WF087-03- Crown Trading Estate, Hayes, London

**RE: Crown Trading Estate, Hayes, London – Wind Microclimate Technical Addendum**

DRAWING NAME
Ground Floor Plan

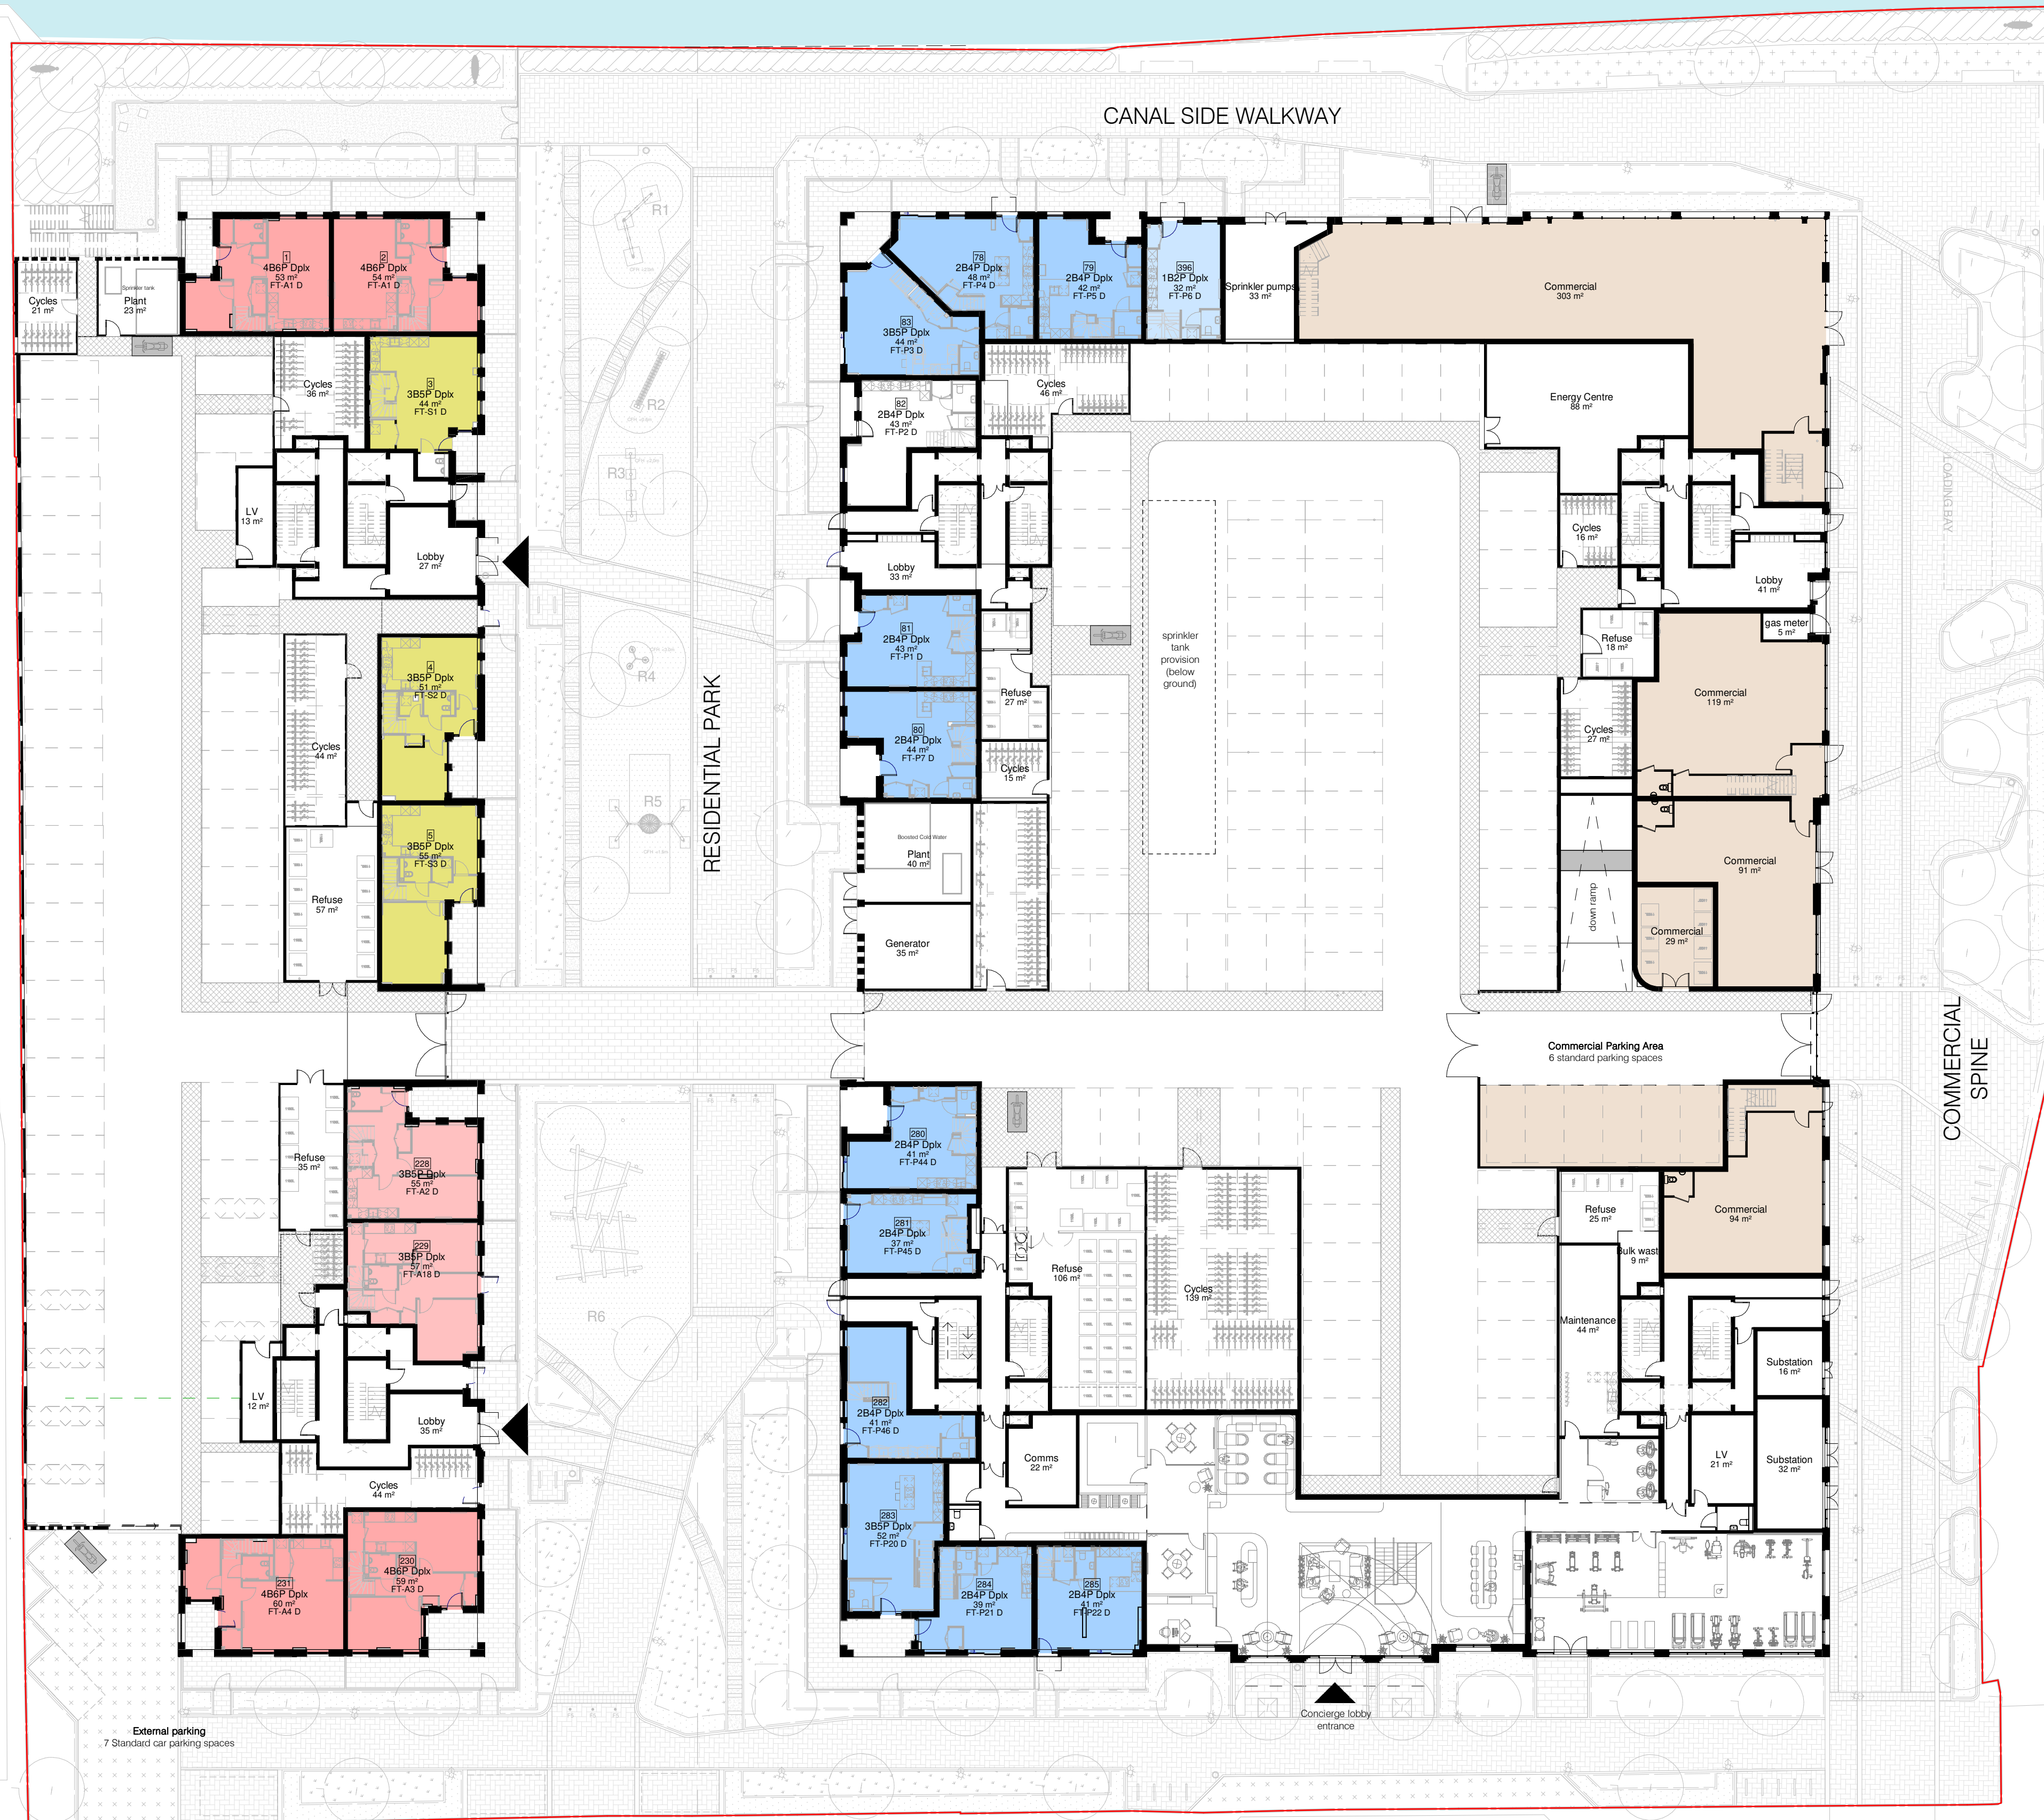
The entrances remain in similar locations and are in areas away from the corners of the buildings. Therefore, it is reasonable to expect that the wind microclimate at the entrances will remain similar.

Eighth Floor Plan

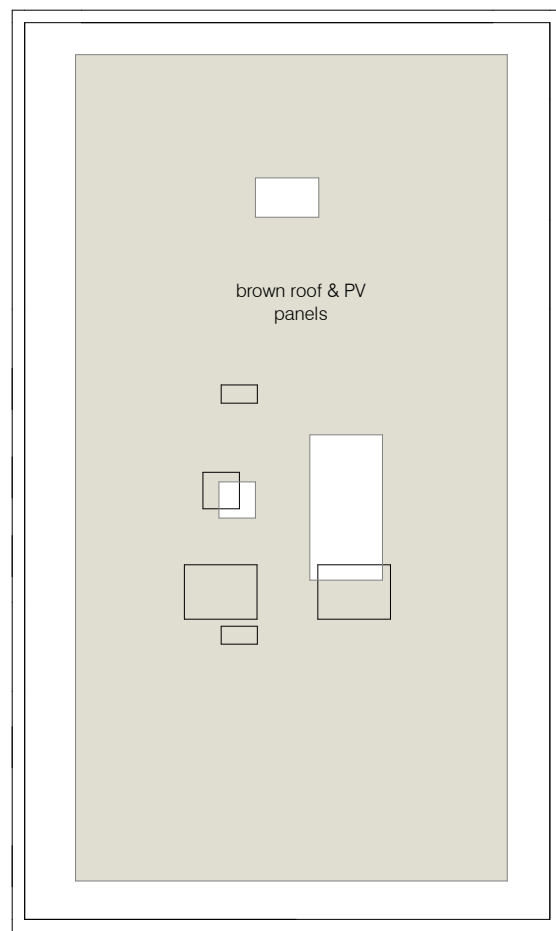
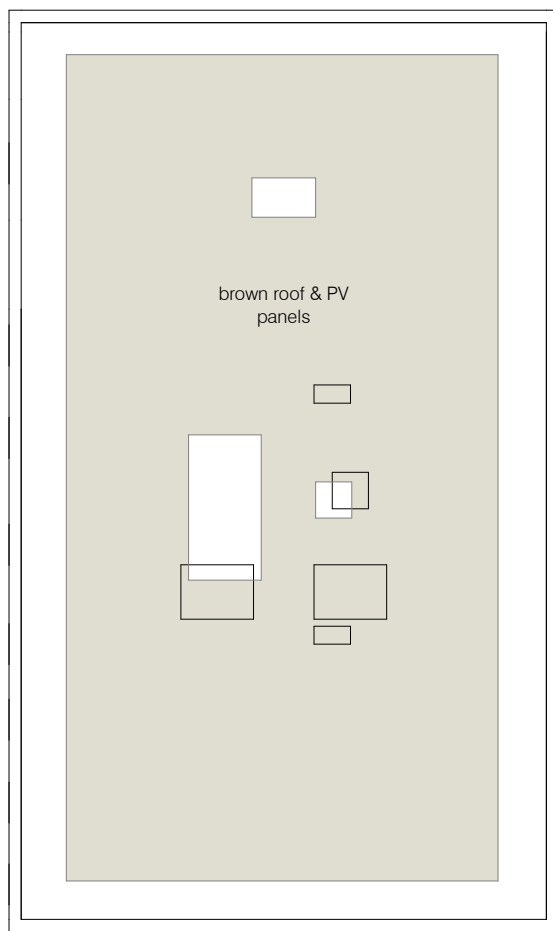
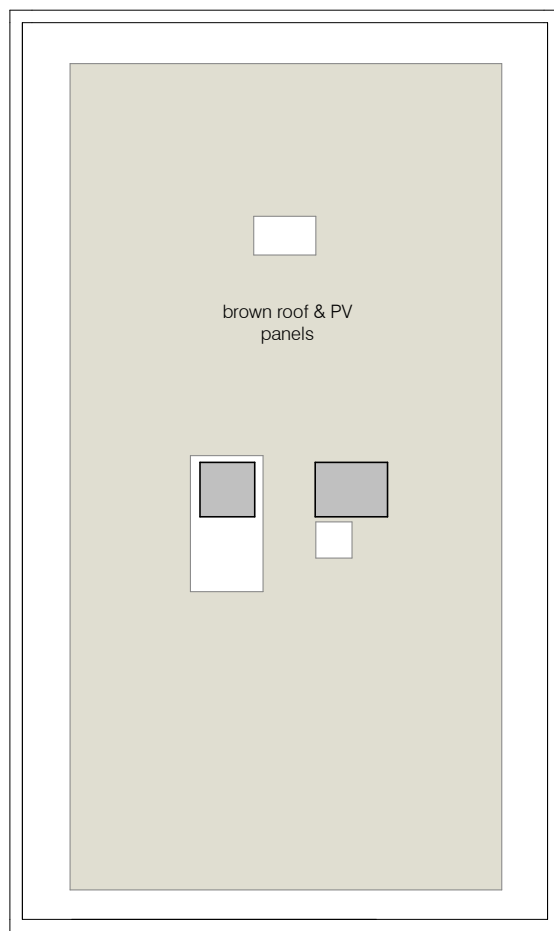
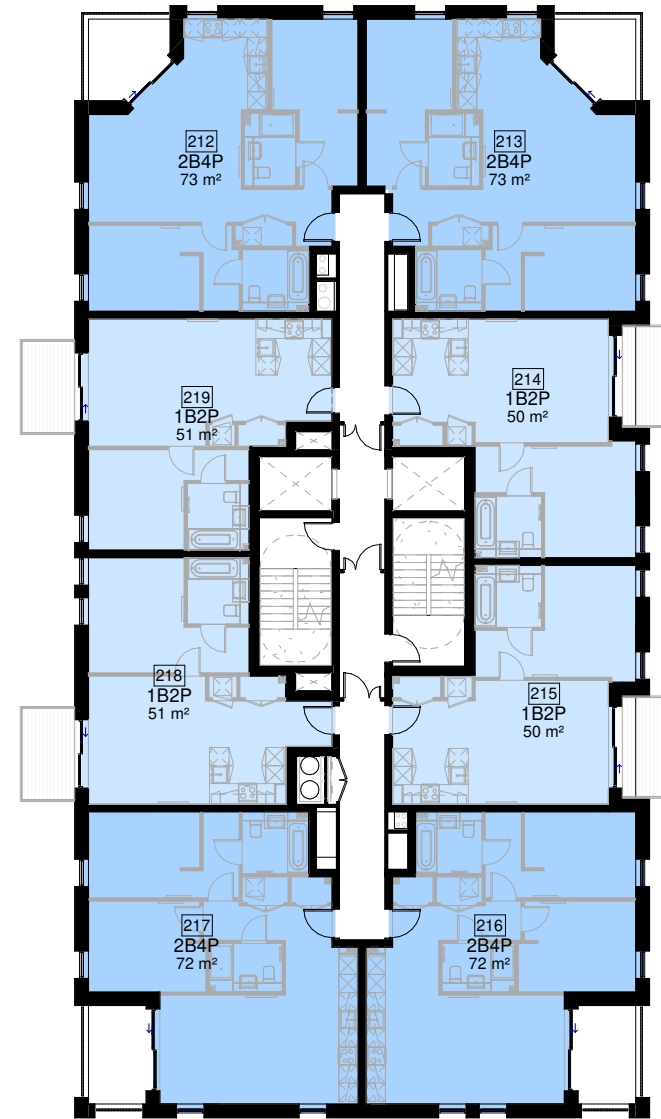
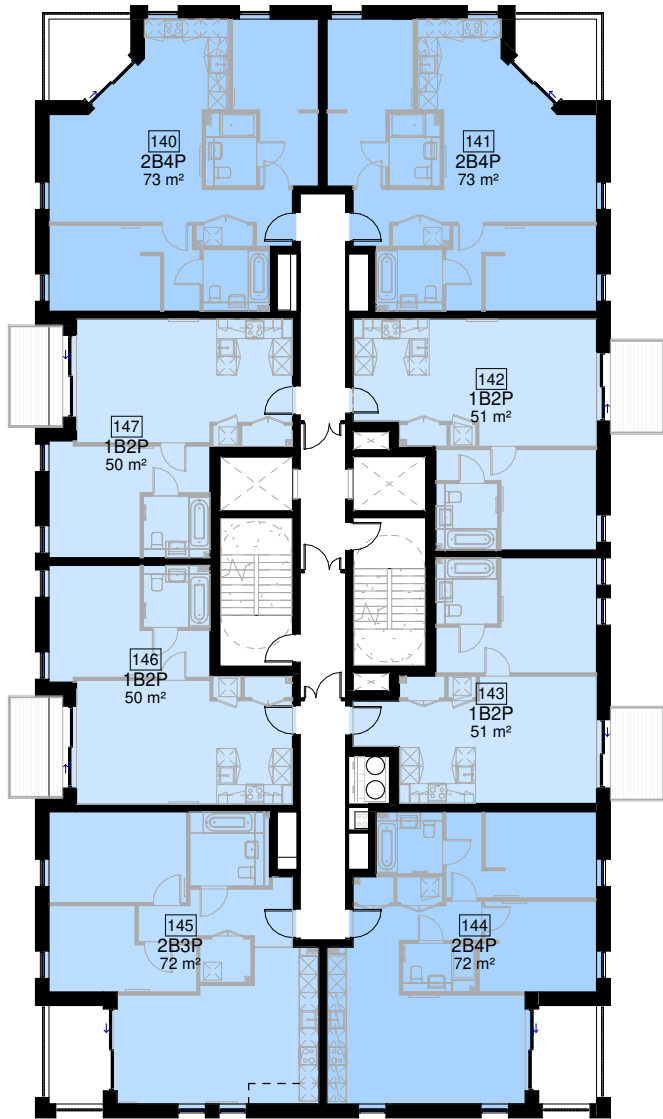
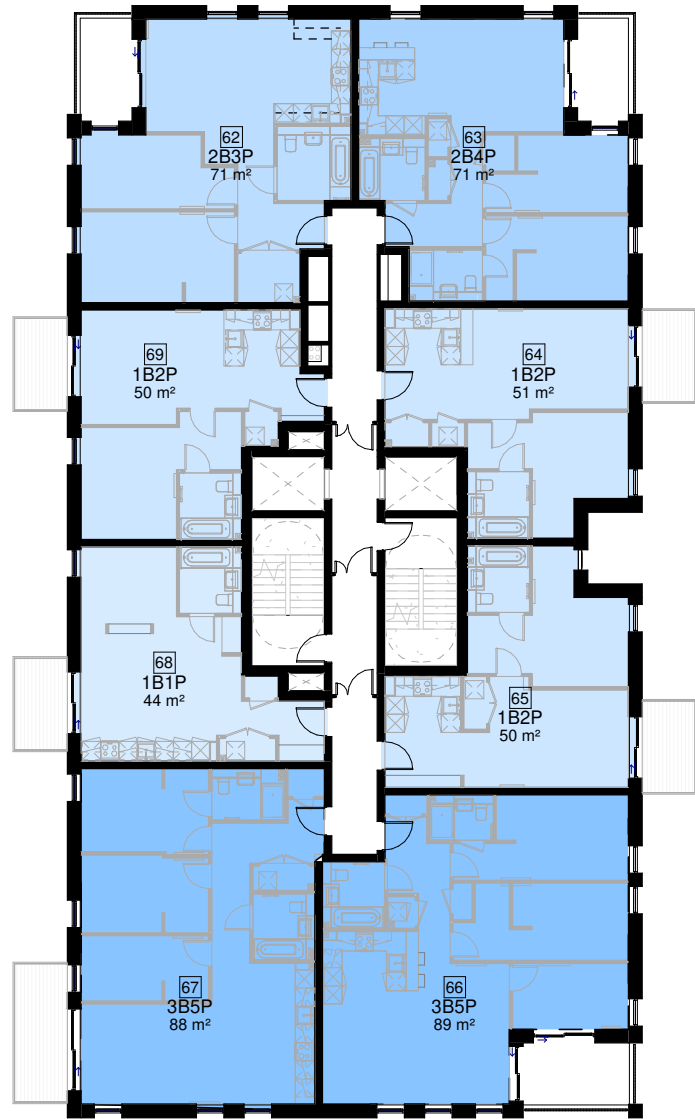
The change in the size of the balconies appears to be minimal. The central façade balconies that have been relocated remain in similar locations and are in areas away from the corners of the buildings. With these considerations in mind, it is reasonable to expect that the wind microclimate on the balconies will remain similar. However, where the balconies are no longer recessed, it is reasonable to expect that the wind microclimate on those balconies will worsen as they will be more exposed to approaching winds.

The previous design of the development included multiple balcony columns on the central facades of the southernmost buildings where the balconies extended beyond the façade. It is reasonable to expect that the wind microclimate on the balconies of the northernmost buildings that will no longer be recessed will be similar to the wind microclimate on the non-recessed balconies of the southernmost buildings.

Considering the conclusions of the previous assessment as well as the massing of the development (particularly relative to the surrounding context), the exposure of the site to the prevailing winds, and the orientation of the buildings, it is recommended that a quantitative study (in the form of CFD or wind tunnel testing) is undertaken to further assess the wind microclimate.
